**RE: Hampton Inn (Holly Ave)
Grading Plan and Drainage Report
Engineer's Stamp Date – 4-22-2016
Hydrology File: C18D073B**

HOLLY HOTEL

DRB Project Number: 1010357

Project: Hampton Hotel

ENGINEER'S SEAL 4/22/16 DAVID SOULE P.E. #14522	HOLLY HAMPTON INN GRADING AND DRAINAGE PLAN 1806 CENTRAL AVENUE SE SUITE 201 ALBUQUERQUE, NM 87106 (505) 872-0999	DRAWN BY WCWJ
		DATE 4-21-16
		21423-LAYOUT-12-05-14
		SHEET # — JOB # 21423

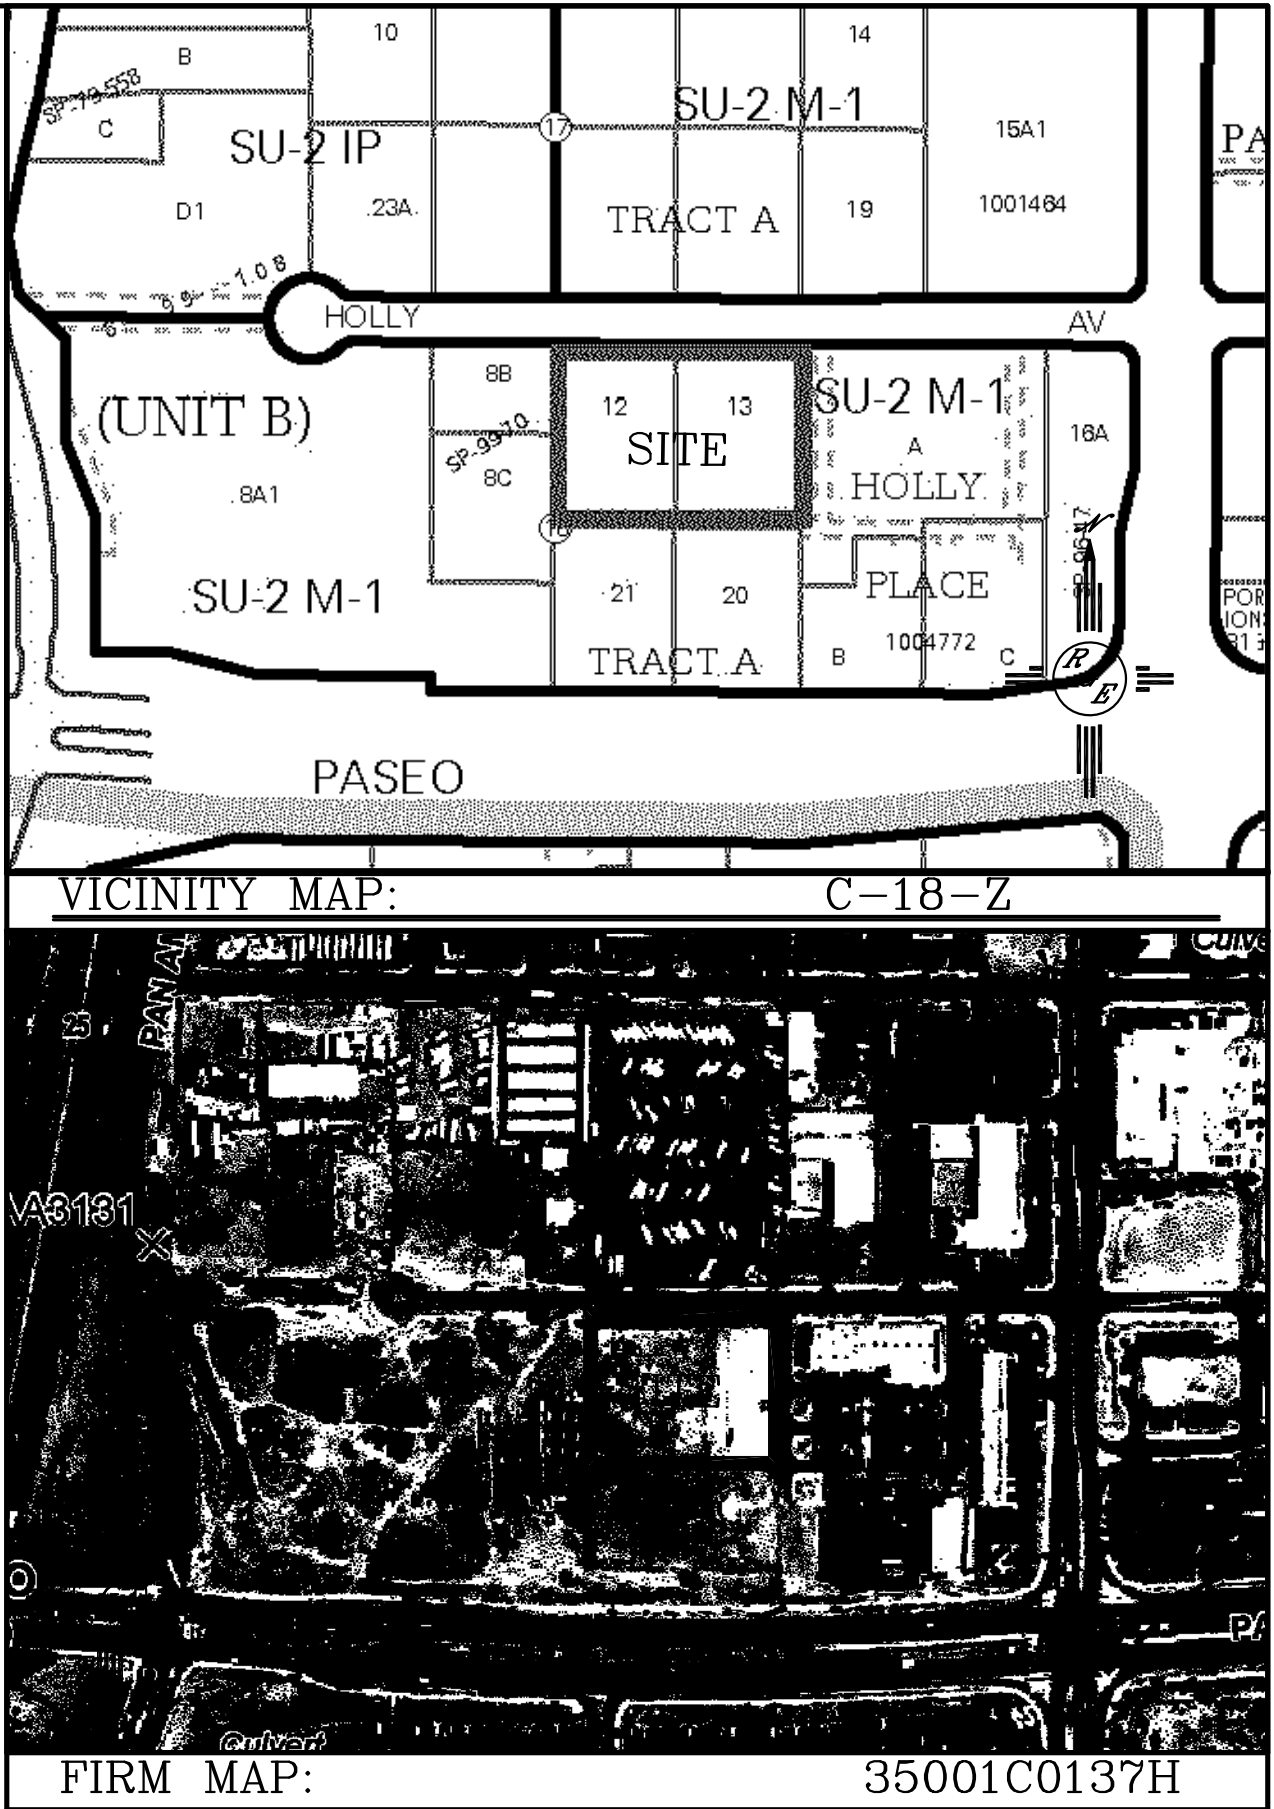
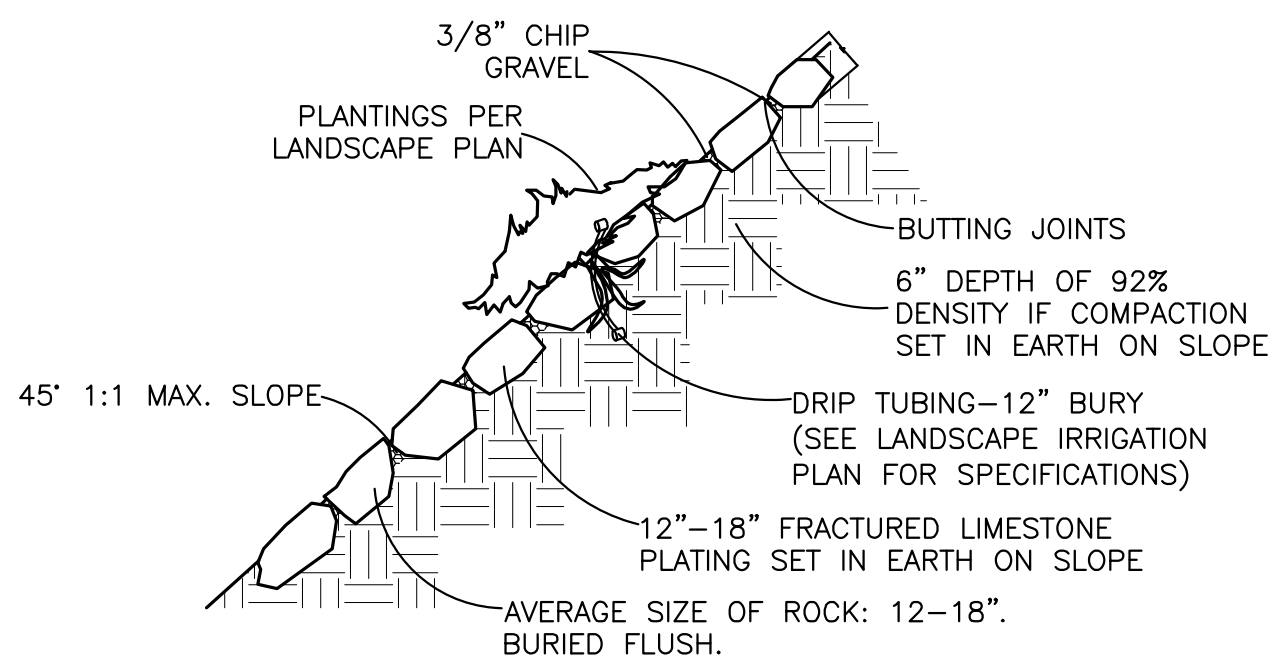
- Hydrology has an approved grading plan, and drainage report (stamp date 11-18-15), for *Site Plan approval*.
- The drainage report states that this site receives inland flows. A private cross lot drainage easement may be needed. We are adding blanket cross lot drainage
- Tract A was to discharge thru a shared access drive along the eastern edge, but it appears from the grading that it now discharges thru this site. Provide supplement to drainage report showing how much flow will be entering from Tract A, and how it will discharge. Flows are accepted, passed thru north drive isle onto holly
- Lots 21 and B1 both discharge thru this site. Was swale was sized to accommodate these flows? Report needs supplement information addressing offsite flows.

Rio Grande Engineering requests DRB approval for site plan for building permit. We have received your comments from the DRB and are intending to answer them in this resubmittal. A blanket cross lot drainage easement is being granted. The water harvest channel has capacity for onsite and upland flows, the flow to the east travel within the north parking lot and discharge to holly. This discharge is consistent with the SAD that the center was developed under

The channel is irregular shaped so we calculated capacity in section. The top section does not have roughness on the bottoms so the capacity is greater show here

We have added channel section calculations
